City of Portland, Maine - Building or Use Permit

Permit No: 05-0834	Date Applied For: 0612312005	CBL: 056 G035001
------------------------------	--	----------------------------

Location of Construction: 253 Spring St	Owner Name: Taylor Terry N &	Owner Address: 26651 Dorothea	Phone:
Business Name:	Contractor Name: Jeff Bailey	Contractor Address: 153 Mechanic St Westbrook	Phone: (207) 632-9349
Lessee/Buyer's Name	Phone:	Permit Type: Alterations - Multi Family	
Proposed Use: Commercial - 3 family repair / restore existing rear porch		Proposed Project Description: Repair / restore existing rear porch

Rear Porch Illustration (elevations)

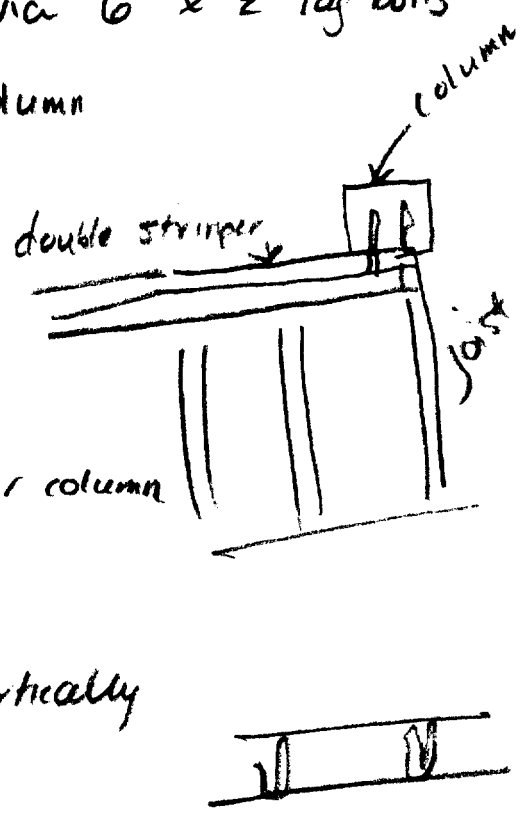
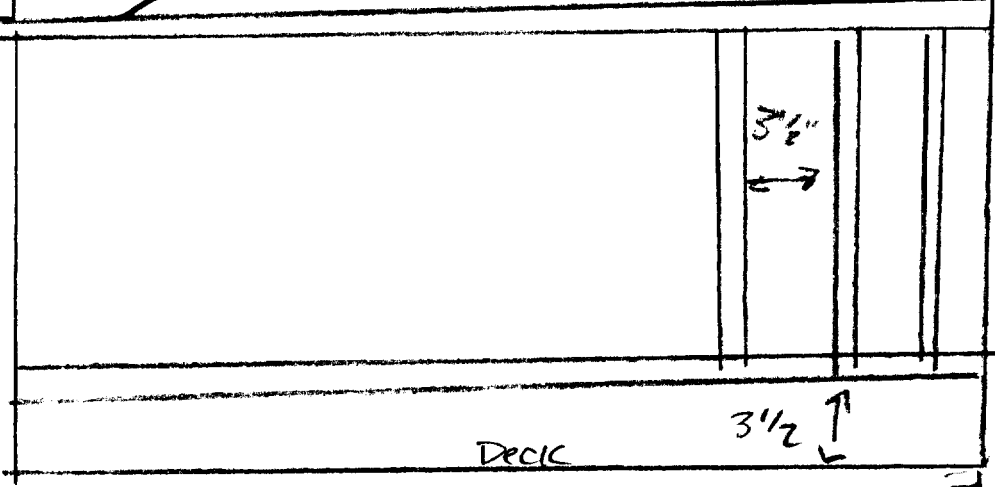
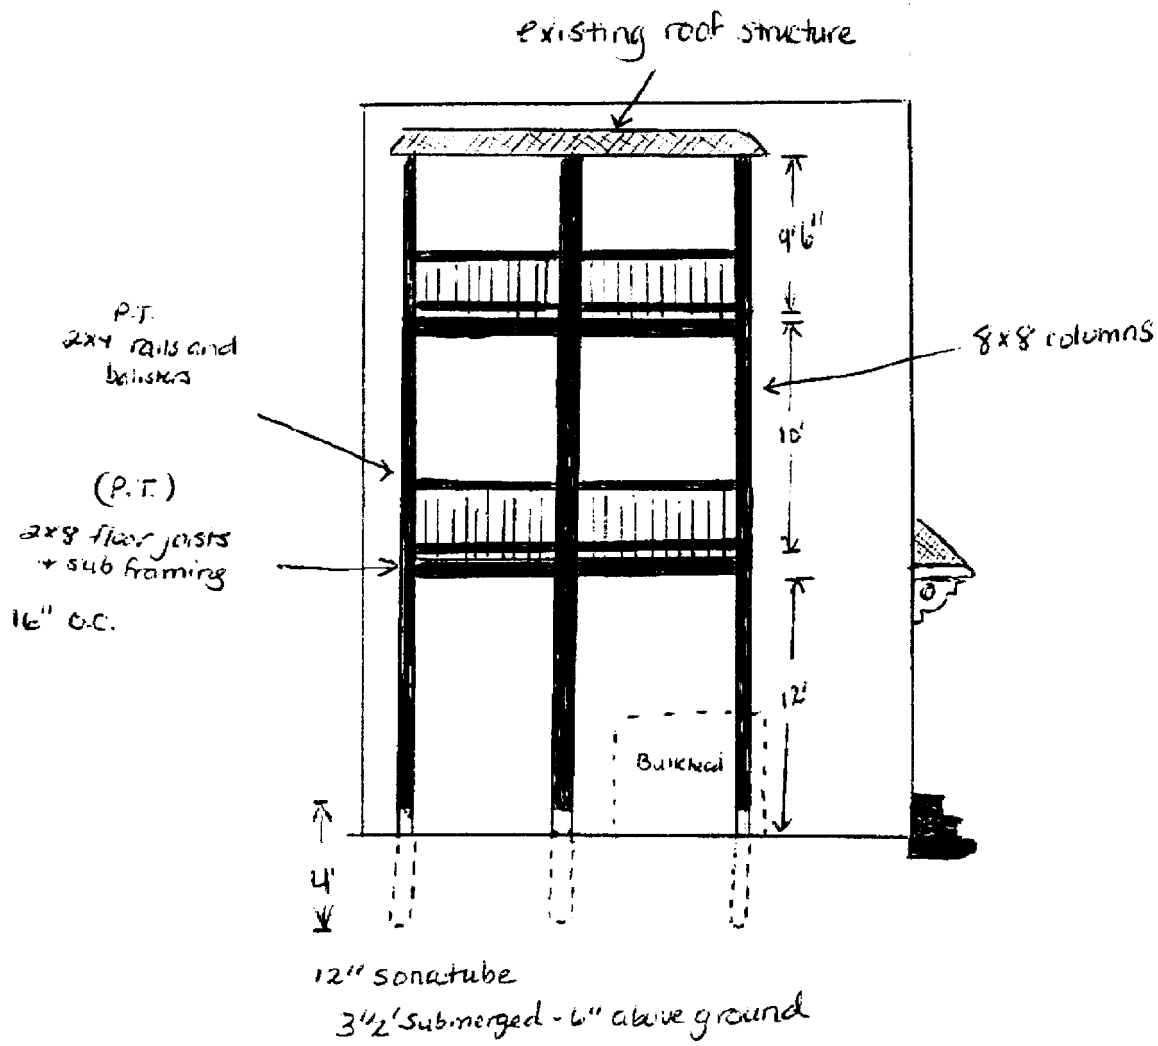
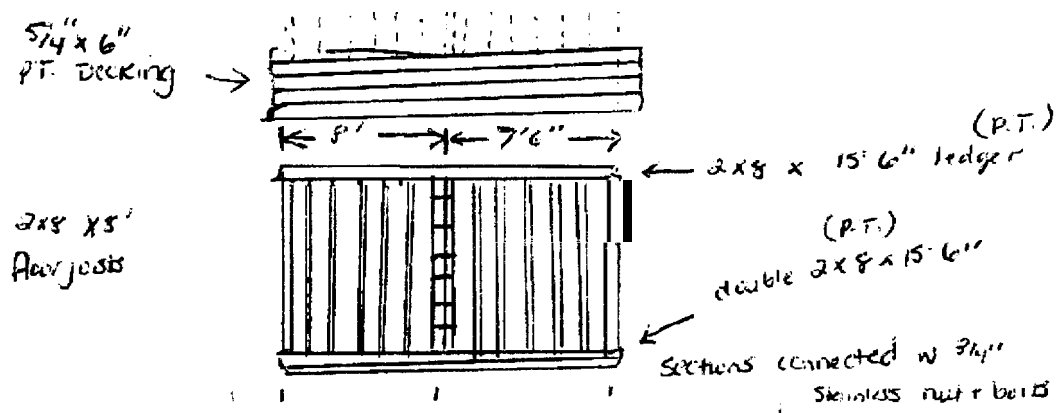
- 1) Positive connection required at the post/footing
- 2) All fasteners to be compatible with the PT wood treatment

06/29/2005-mjn: need better structural plans / guard details etc.....Builder notified
